DRB Application No.: 09DRB-70101 Project # 1007008  
Project Name: Graceland Acres Addn.  
Agent: Darren Sowell Architects Phone No.:

**DRB Comments**

**PROJECT # 1007008**

**Date:** Feb. 2, 2009  
**To:** Jack Cloud, DRB Chair  
**From:** Carol Toffaleti, Staff Planner, Development Review, 924-3345  
**cc:** Craig Calvert, DSA Architects  
**Subject:** Project #1007008 – JLM Auto Sales at Candelaria/Arno  
07EPC-40104 Zone Map Amendment, 08EPC-40086 Site Development  
Plan for Building Permit

1 CONCEPTUAL UTILITY PLAN  
 1" = 20'

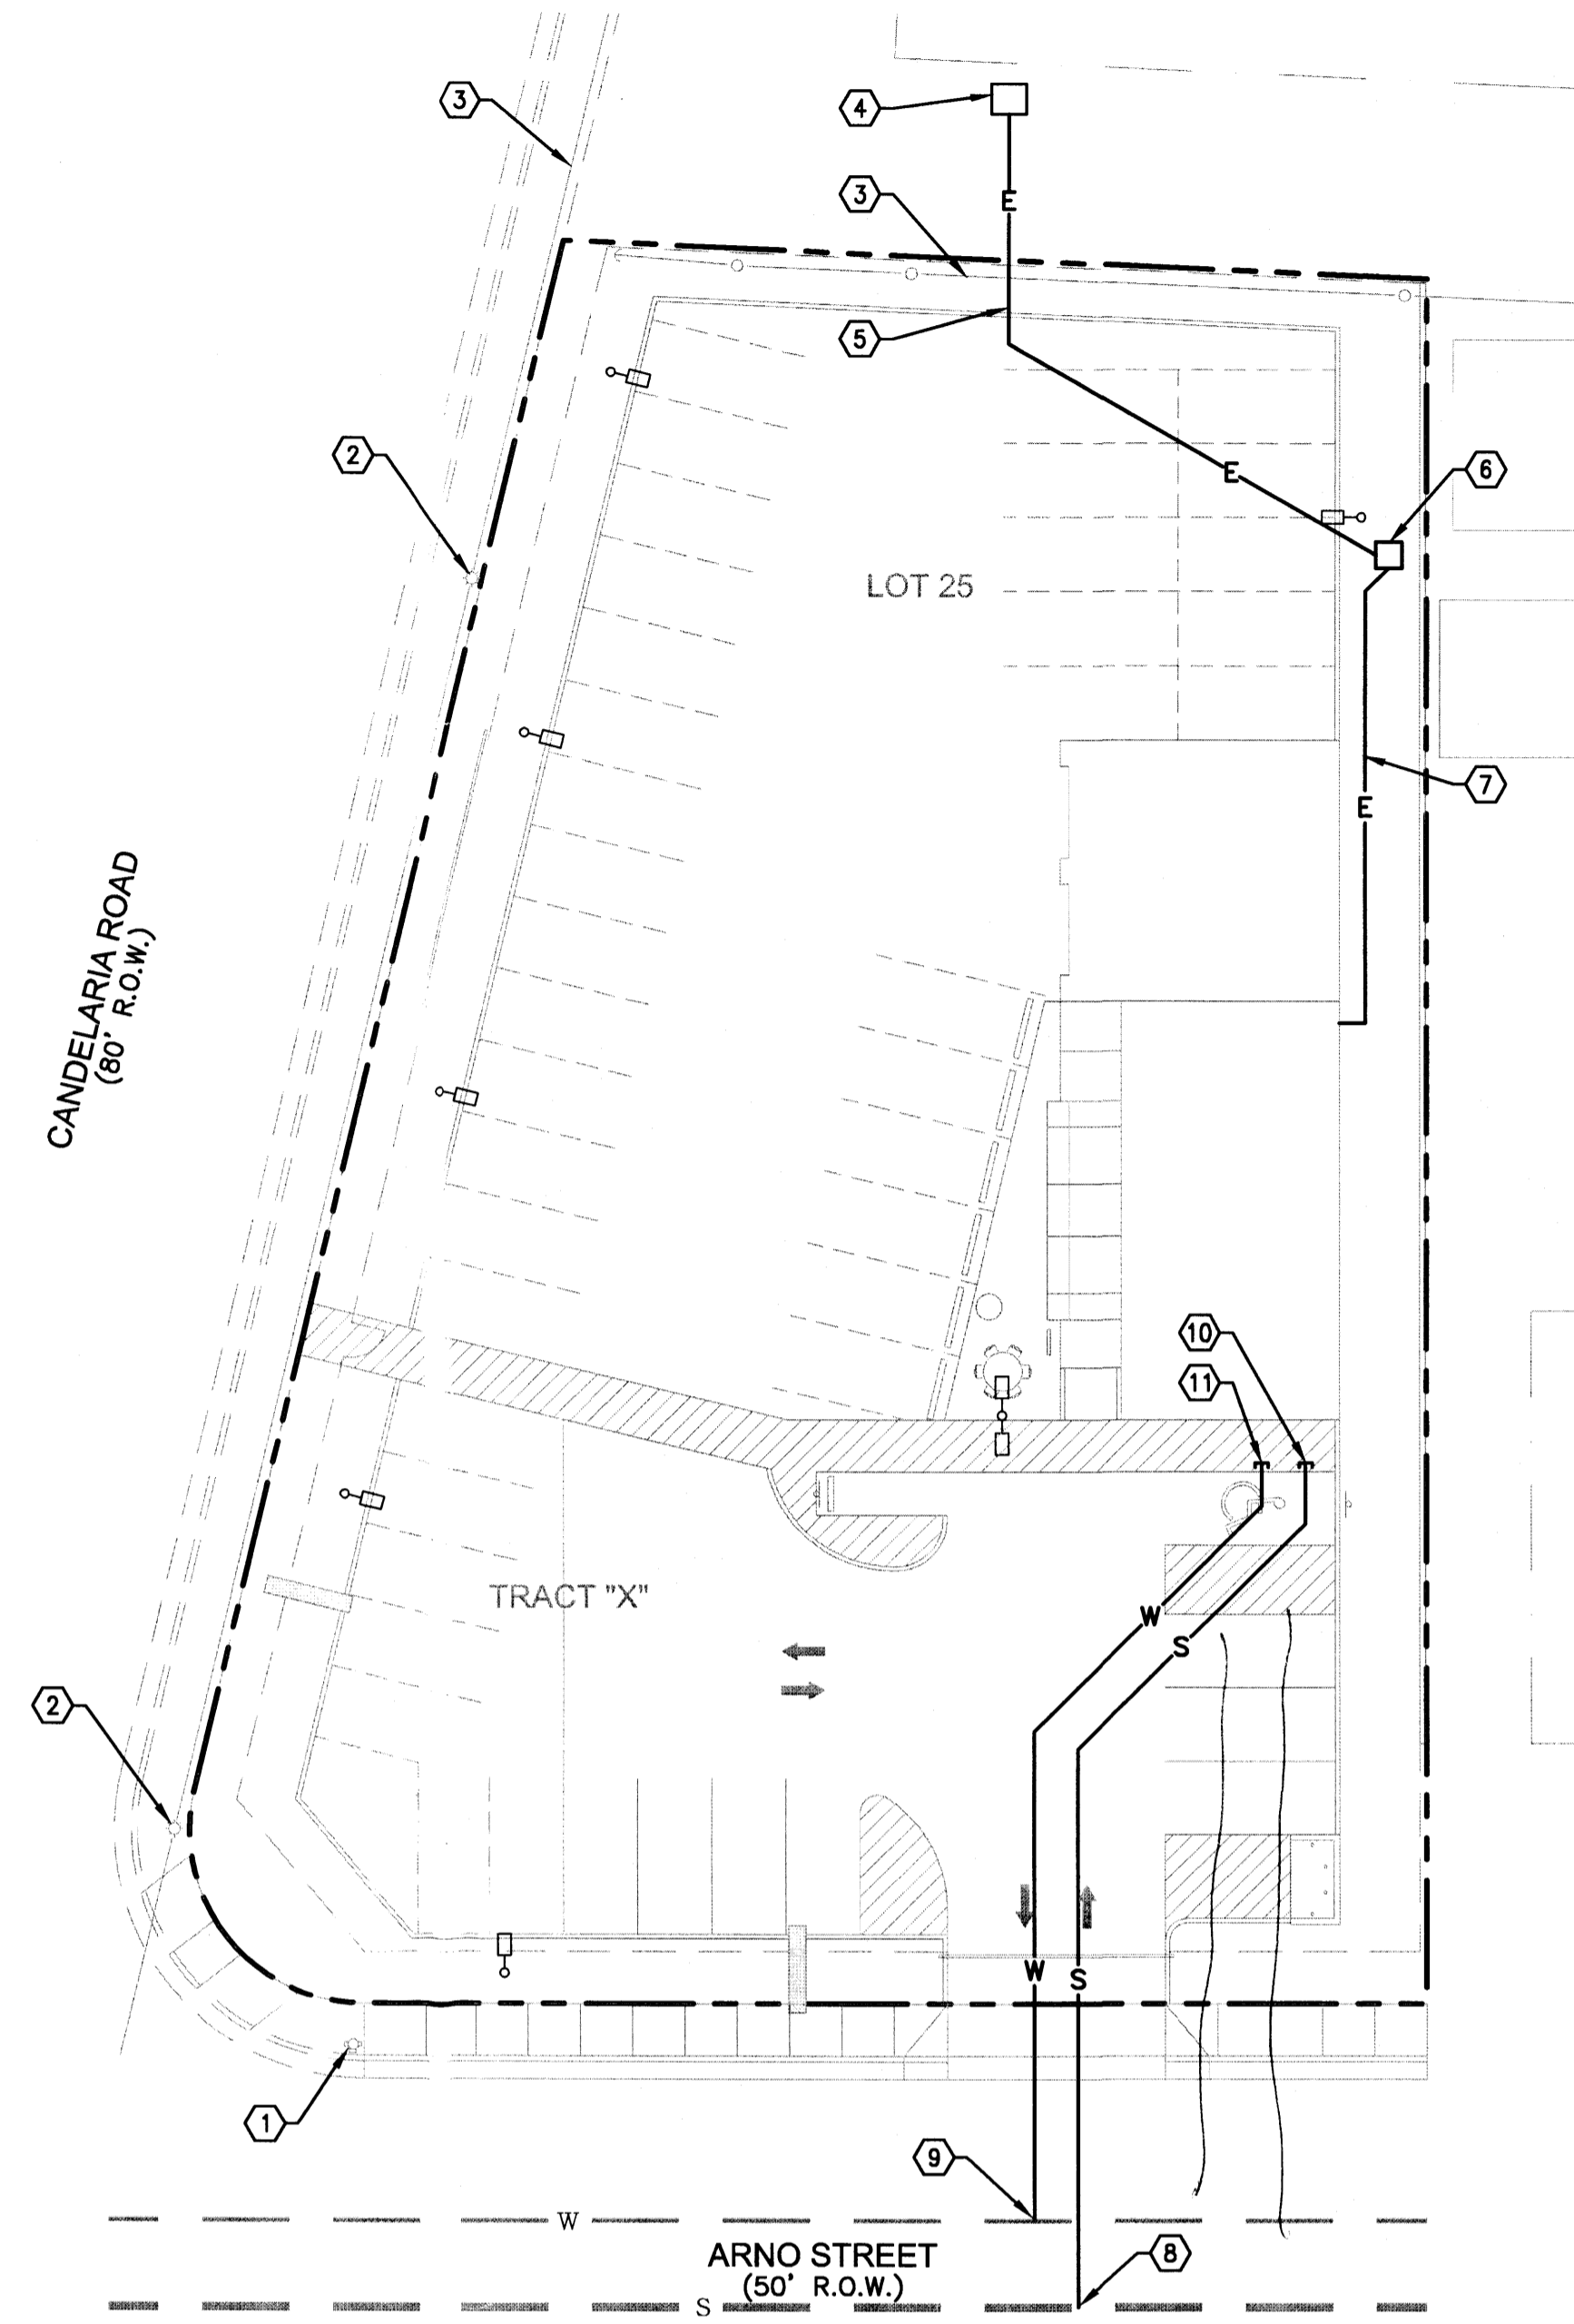
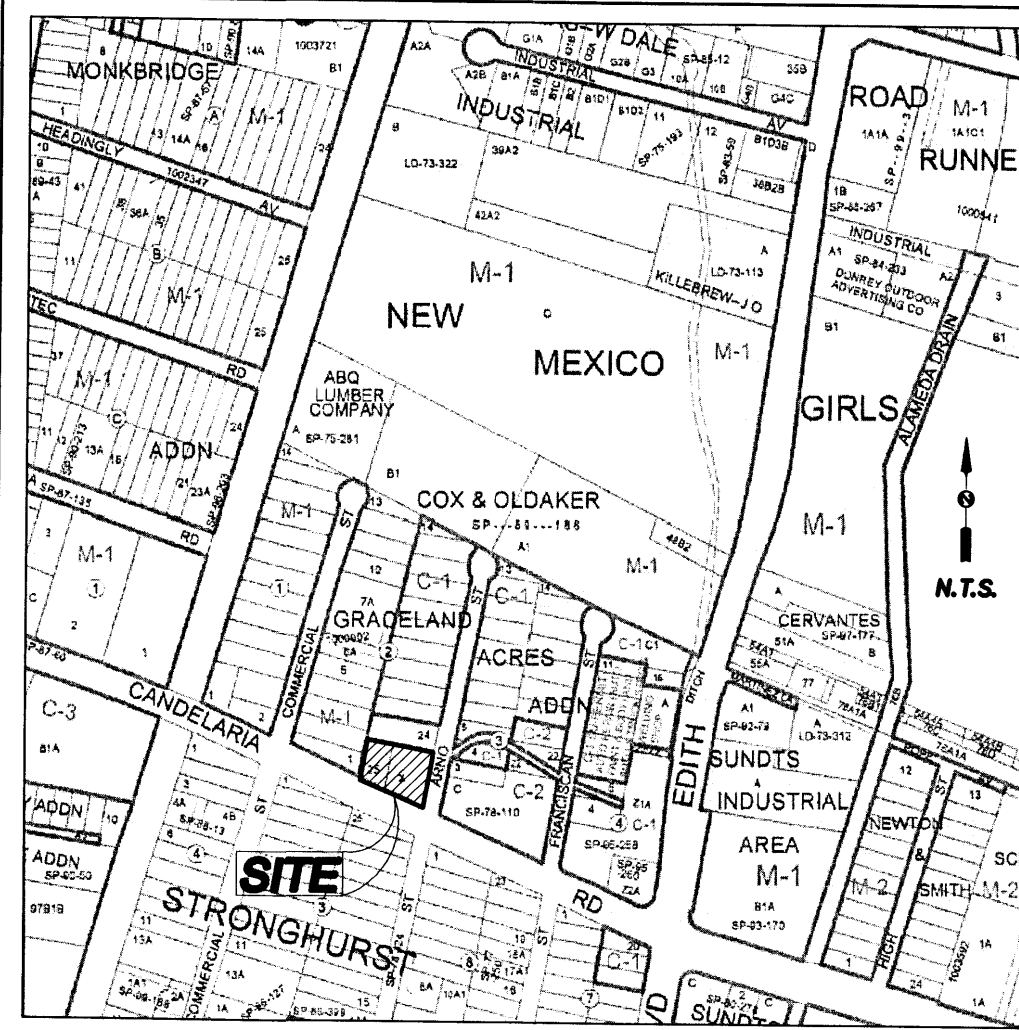
PLANNING (Last to sign): - ADRR lettering on cover sheet  
- routing Utility Plan  
- Site Work Plan
